Project: I5719B – U5800 Design Build

Subject: Hydraulics CP4B Meeting - Minutes

Date: Wednesday, April 15, 2026

PROFILE ALONG 78" WELDED STEEL – SITE 10

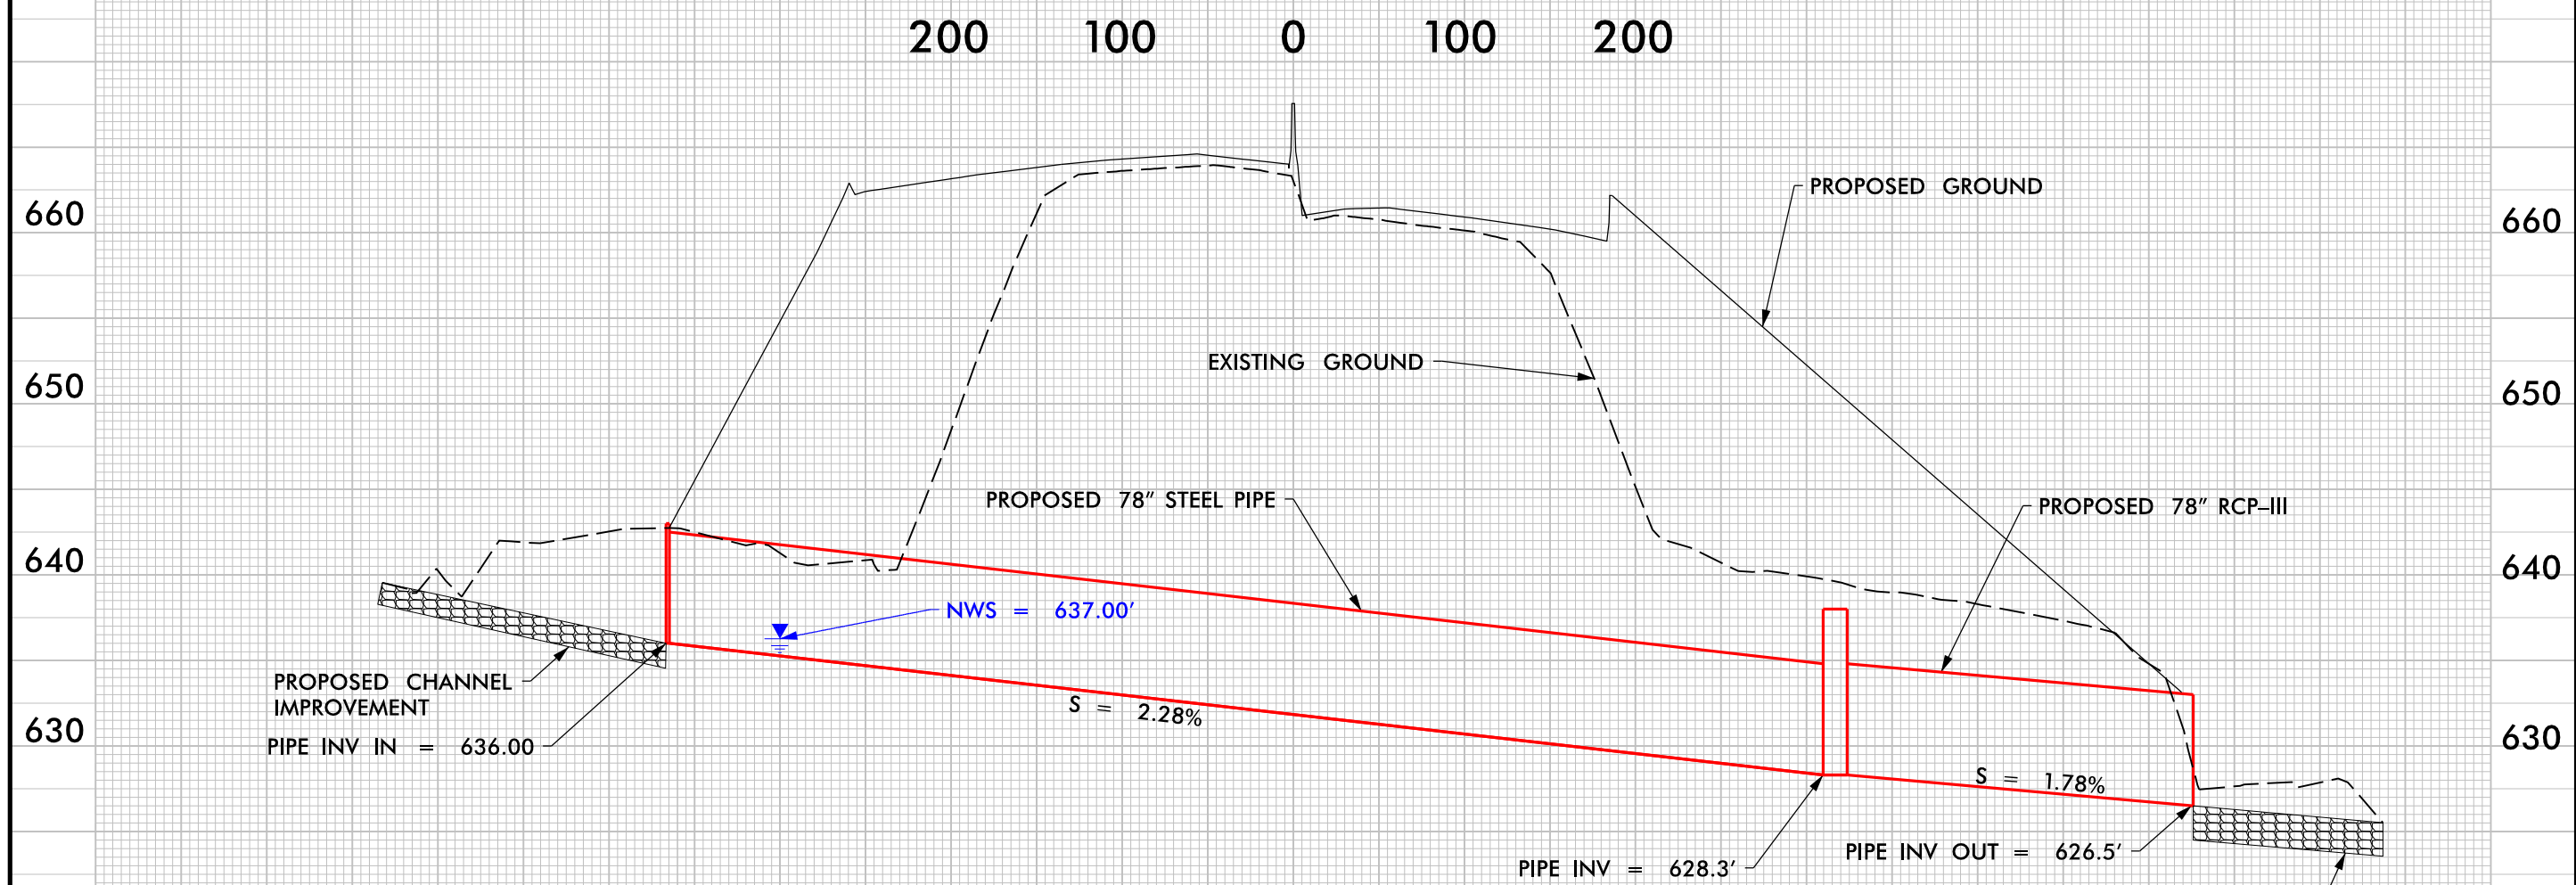
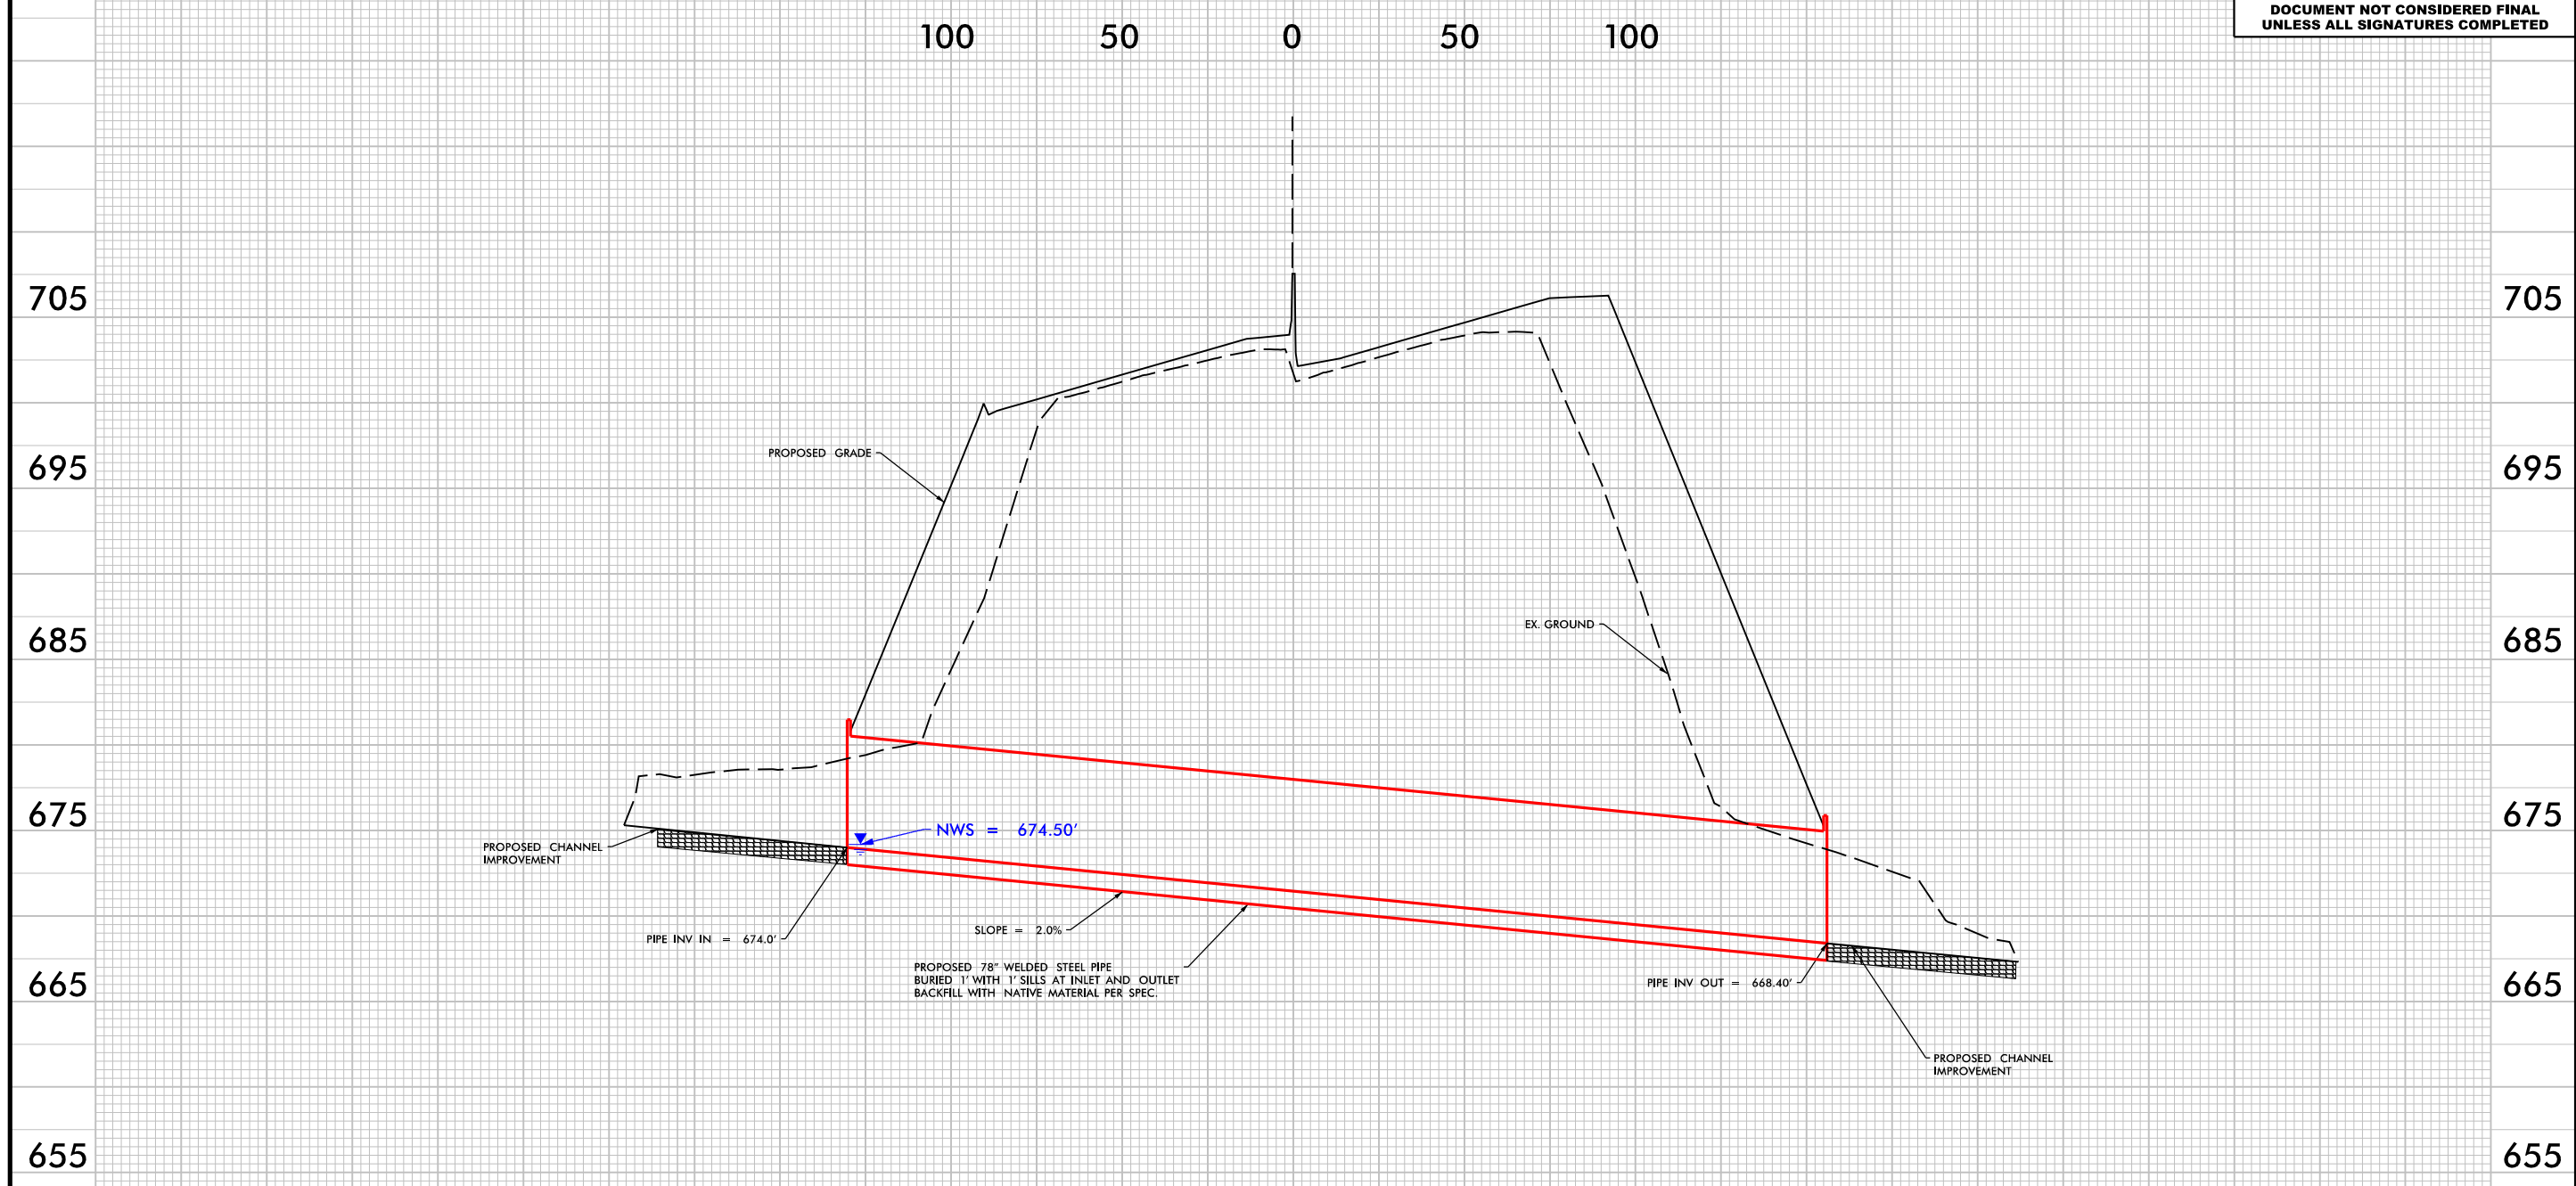
- Stream SK – UT at Belmont Abbey College – FEMA Stream
  - Existing 54" RCP
  - Replacing with 78" Smooth Steel Pipe
    - Currently showing buried 1 ft
    - Pipe slope = 1.4% Vel<sub>10</sub> = 16 fps
    - If buried, need to discuss sills
  - Upstream
    - Tying in stream channel approximately 70'
    - Showing Rip Rap keyed into the bottom of the stream
  - Downstream
    - Tying in stream channel approximately 40'
    - Showing Rip Rap keyed into the bottom of the stream
- **Parisa Sarzaeim – Clarify pipe size. Tom Miller confirmed 78" is the correct size; profile is incorrect and will be revised.**
- **Crystal Amschler asked to clarify if the pipe will be buried. James Rice confirmed that the pipe will be buried and will call for sills at each end.**
